Tomingley Gold Mine Submissions Report

Project Approval No. 09_0155

Modification 4

March 2020

Activities approved under PA 09_0155, as modified, include the following (**Figure 2**).

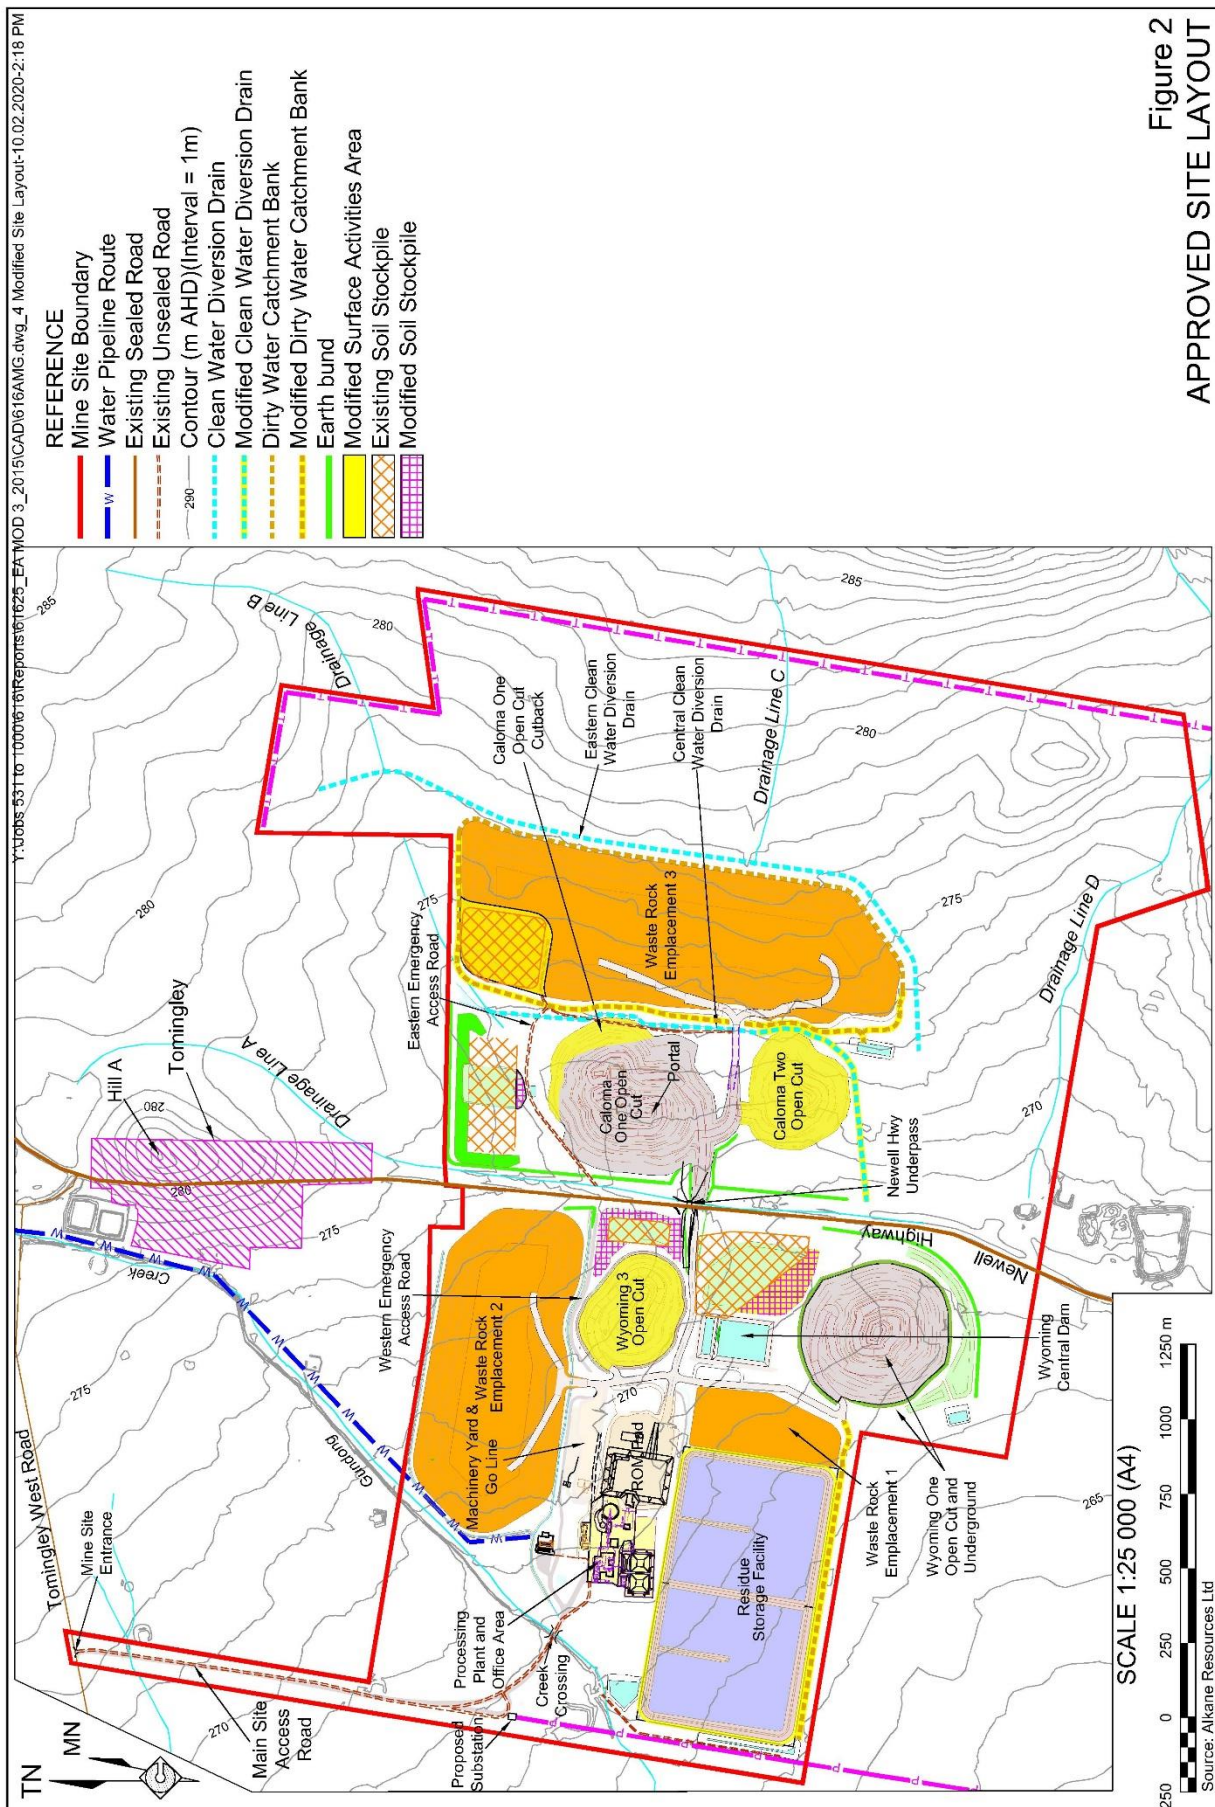
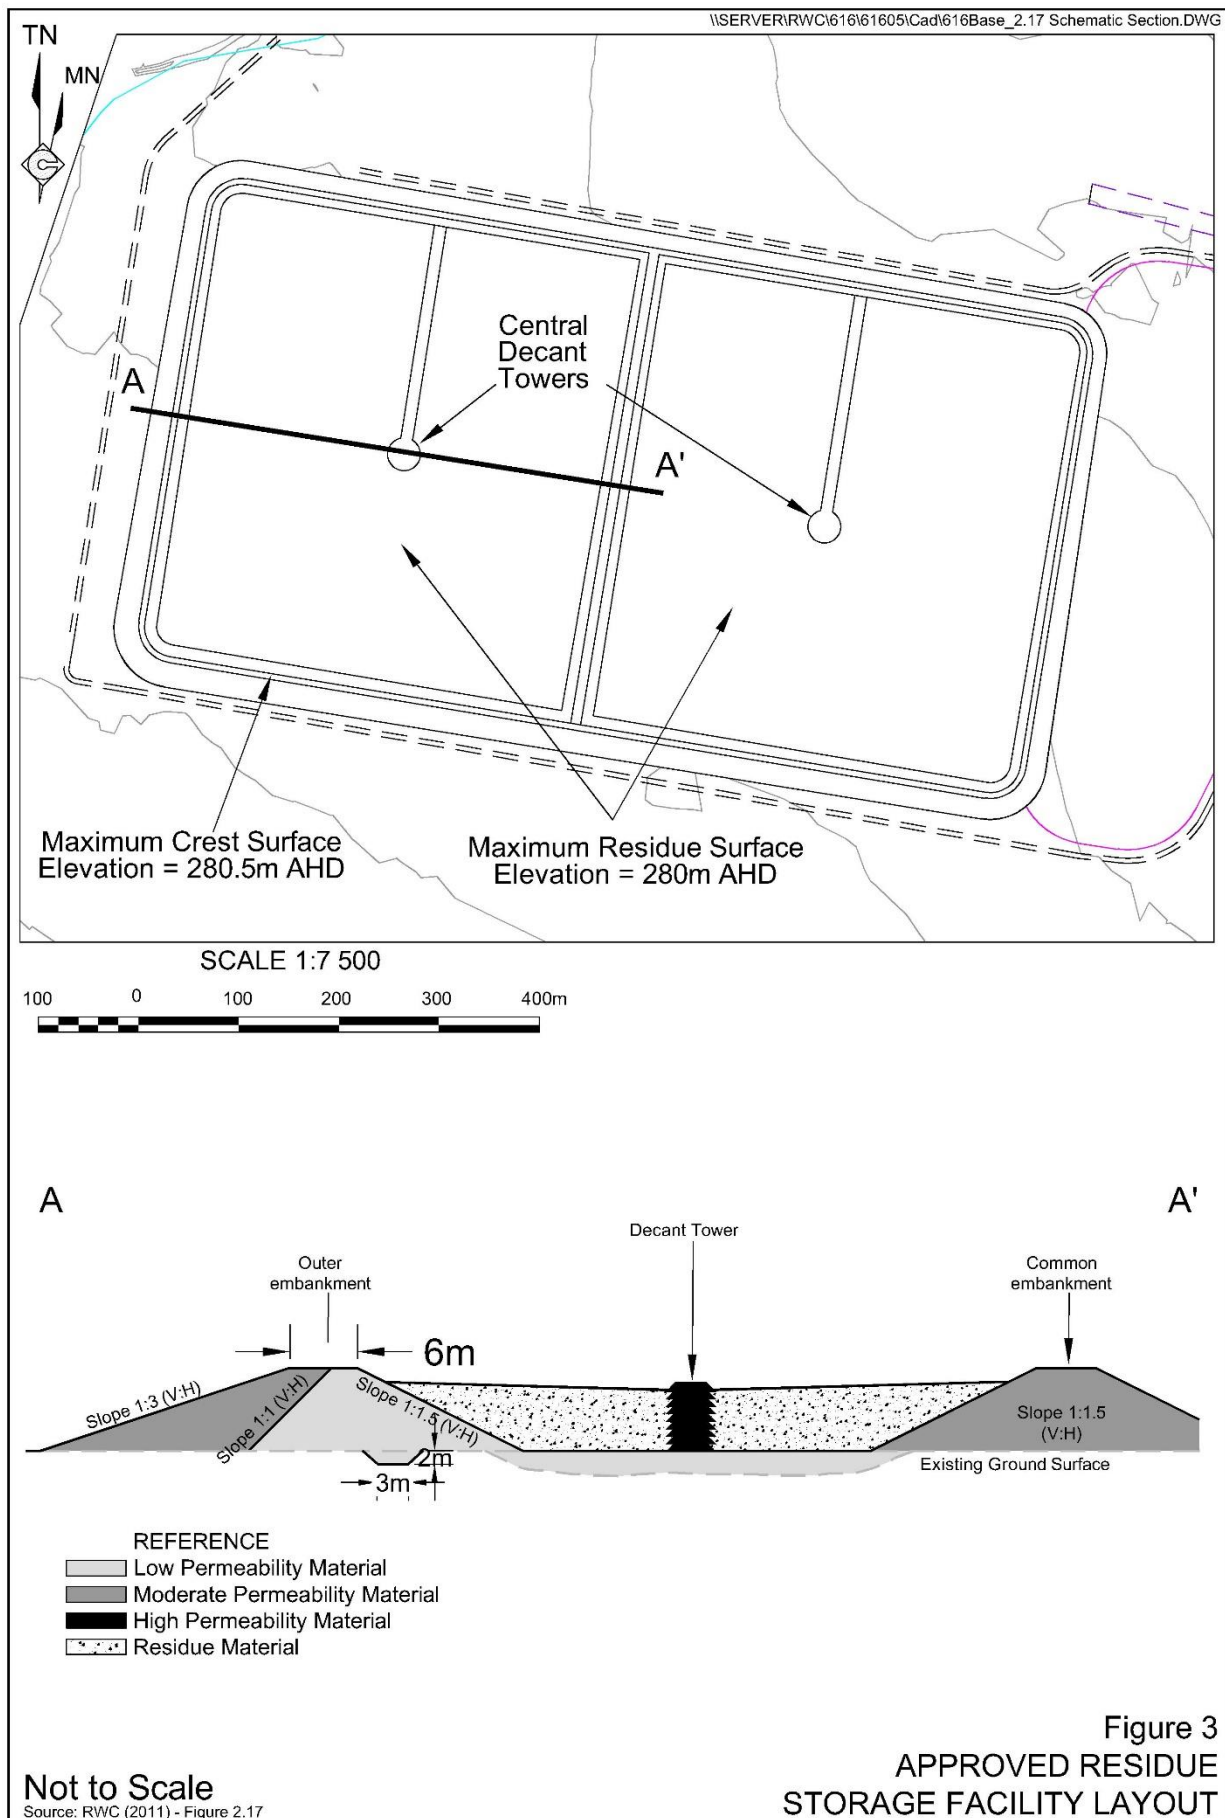
Please provide an updated Figure 2 of the Modification Report to reflect all the currently approved infrastructures, and include all the surface water structures (for both processed water and mine water)

Figure 1 presents the approved site layout, including water management structures.
